CITY OF ALBUQUERQUE

**Re: US Eagle Credit Unit - Menaul
7201 Menaul NE
Traffic Circulation Layout
Engineer's 10-09-2020 (H19-D090)**

Based upon the information provided in your submittal received 10-16-2020, the above referenced plan cannot be approved for Building Permit until the following comments are addressed:

Sheet No.
C-100

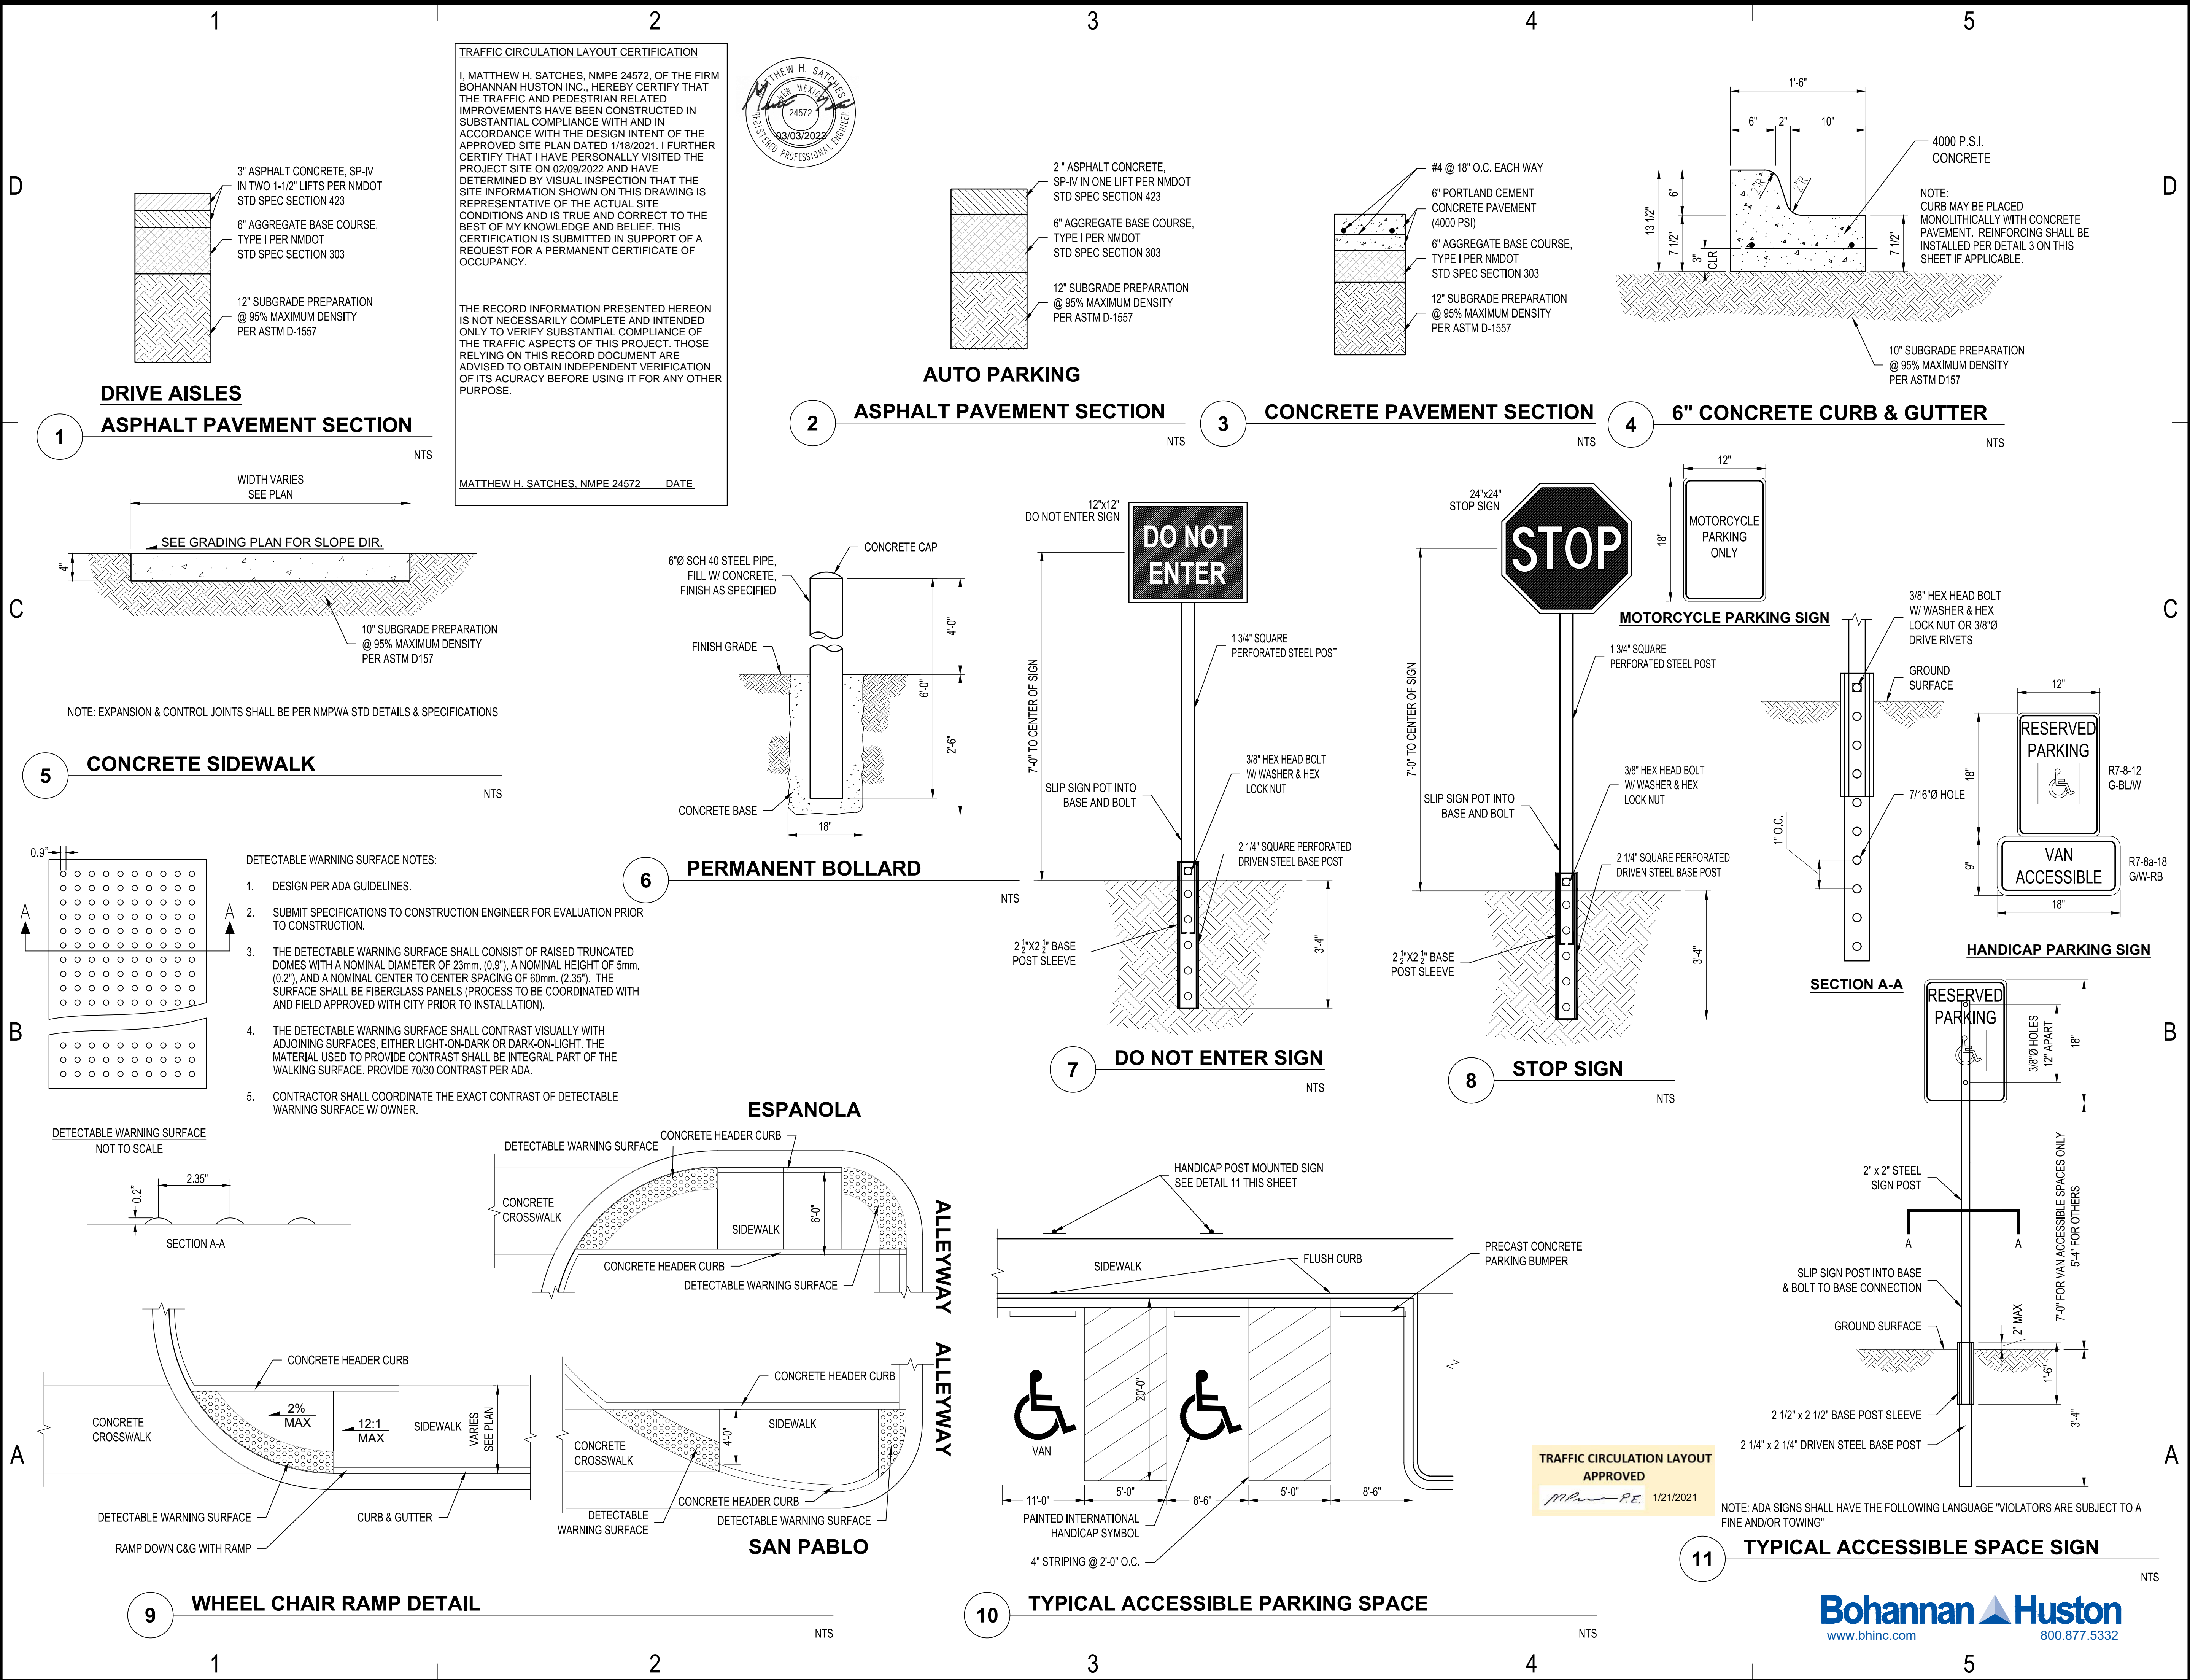
1. Please show a vicinity map showing the location of the development in relation to streets and well known landmarks.
2. The listed number of parking spaces required by the zoning code as well as the proposed number of parking spaces including bicycle and motorcycle parking. All proposed required calculations need to be discussed with Zoning.
3. All existing public infrastructure (sidewalk needs to be located within COA ROW or else a revocable permit will be required especially on the two corners of Menaul and the side streets. Do you need ROW dedication on these corners? Please address and verify these corners/issues.
4. Identify all existing access easements and rights of way width dimensions (If applicable).
5. Maximum access width for local streets (**Espanola St**) are as follows:

6. Please list the width and length for all proposed sidewalk within public. Some dimensions are not shown.
7. The minimum parking stall dimensions are:

8. The ADA accessible spaces must include an access aisle. **Van accessible aisles** should be **8ft wide**; all others should be 5ft wide.
9. The ADA accessible parking sign must have the required language per 66-7-352.4C NMSA 1978 **"Violators Are Subject to a Fine and/or Towing."** Please call out detail and location of signs.

10. The ADA access aisles shall have the words "NO PARKING" in capital letters, each of which shall be at least one foot high and at least two inches wide, placed at the rear of the parking space so as to be close to where an adjacent vehicle's rear tire would be placed. (66-1-4.1.B NMSA 1978).

11. Existing ADA curb ramps must be updated to current standards and have truncated domes installed located on Menaul (**verify if they comply**).
12. Motorcycle parking spaces shall be designated by its own conspicuously posted upright sign, either free-standing or wall mounted per the zoning code (**Provide sign face detail**) and Label pavement MC.

17. Per the IDO, a **6 ft. wide ADA accessible pedestrian pathway** is required from the public sidewalk to the building entrances. Please clearly show this pathway and provide details/label.
18. Please add a note on the plan stating "All improvements located in the Right of Way must be included on the work order."
19. Unused curb cuts must be replaced with sidewalk and curb & gutter. A build note must be provided referring to the appropriate City Standard drawing (If applicable).
20. Add a note stating "All broken or cracked sidewalk must be replaced with sidewalk and curb & gutter." A build note must be provided referring to the appropriate City Standard drawing.
